From: Simon Davis
Sent: 31 July 2018 10:36
To: 'Richard Goodall'
Subject: RE: P/43/18/DOC Sefter Farm

We have just had a comment from our Landscape officer to say: "The information provided in Constructed Wetland Draft Layout dwg 017 rev 07 details an indicative screen

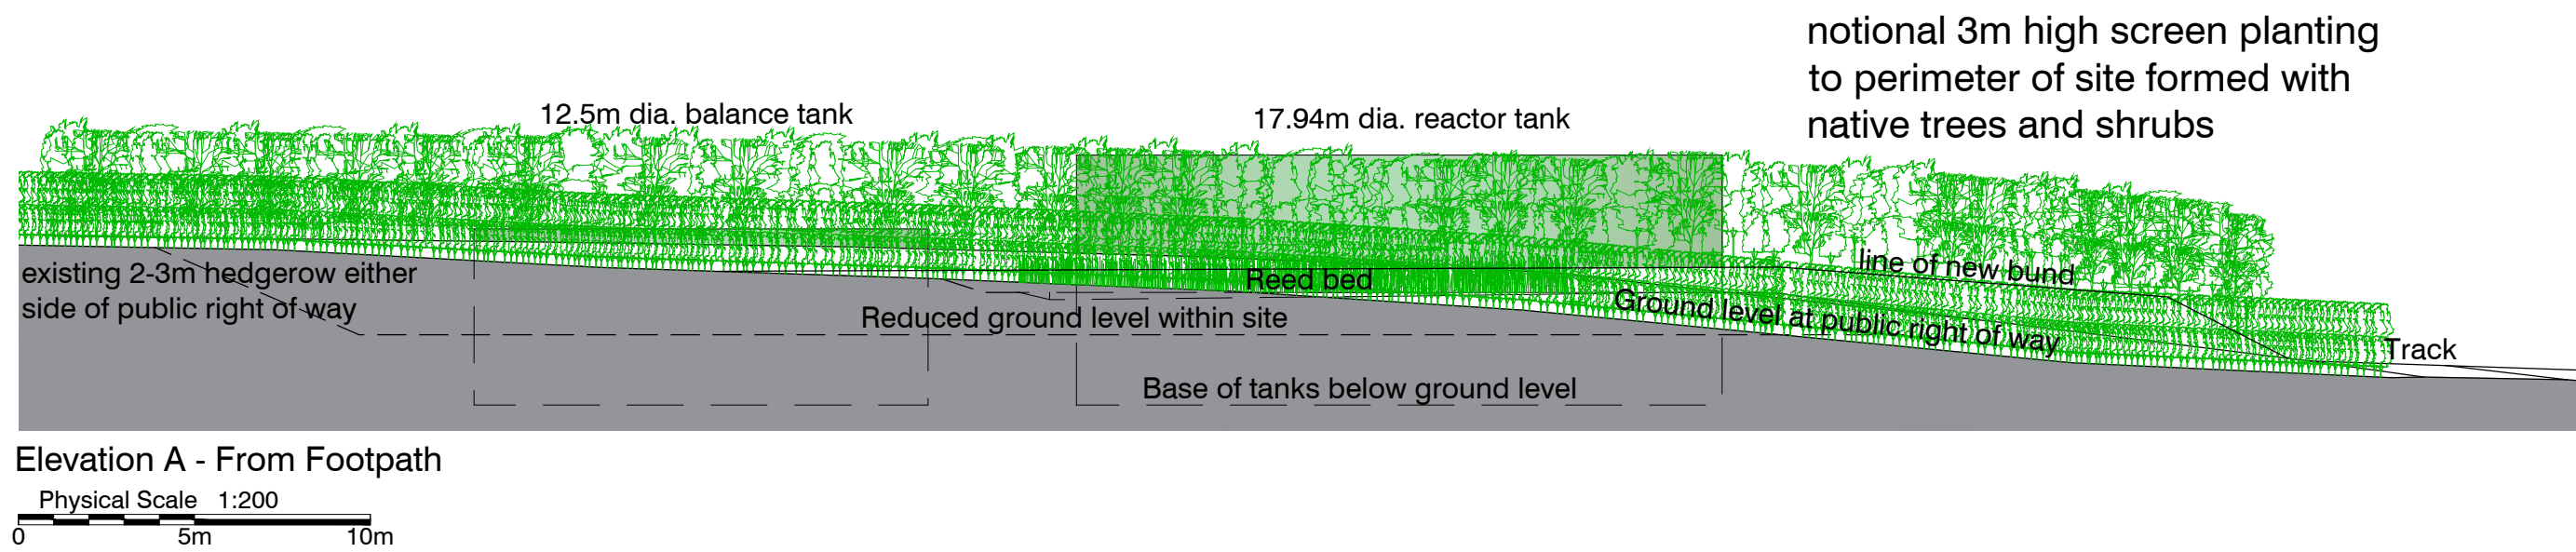
planting to the perimeter which is shown as native planting. Whilst this is suitable for location the detail is not sufficient enough and needs to detail in plan form actual species choice, planting density and size at time of planting. This information needs to be submitted for approval before condition 11 re Landscaping can be considered for discharge. We would therefore not recommend the discharge of Condition 11 landscape scheme until the above information has been submitted for approval.

There are no objections from our ecologist or Nat England but I would request that the drawing be changed as per the above before we can determine this. I look forward to hearing from you.
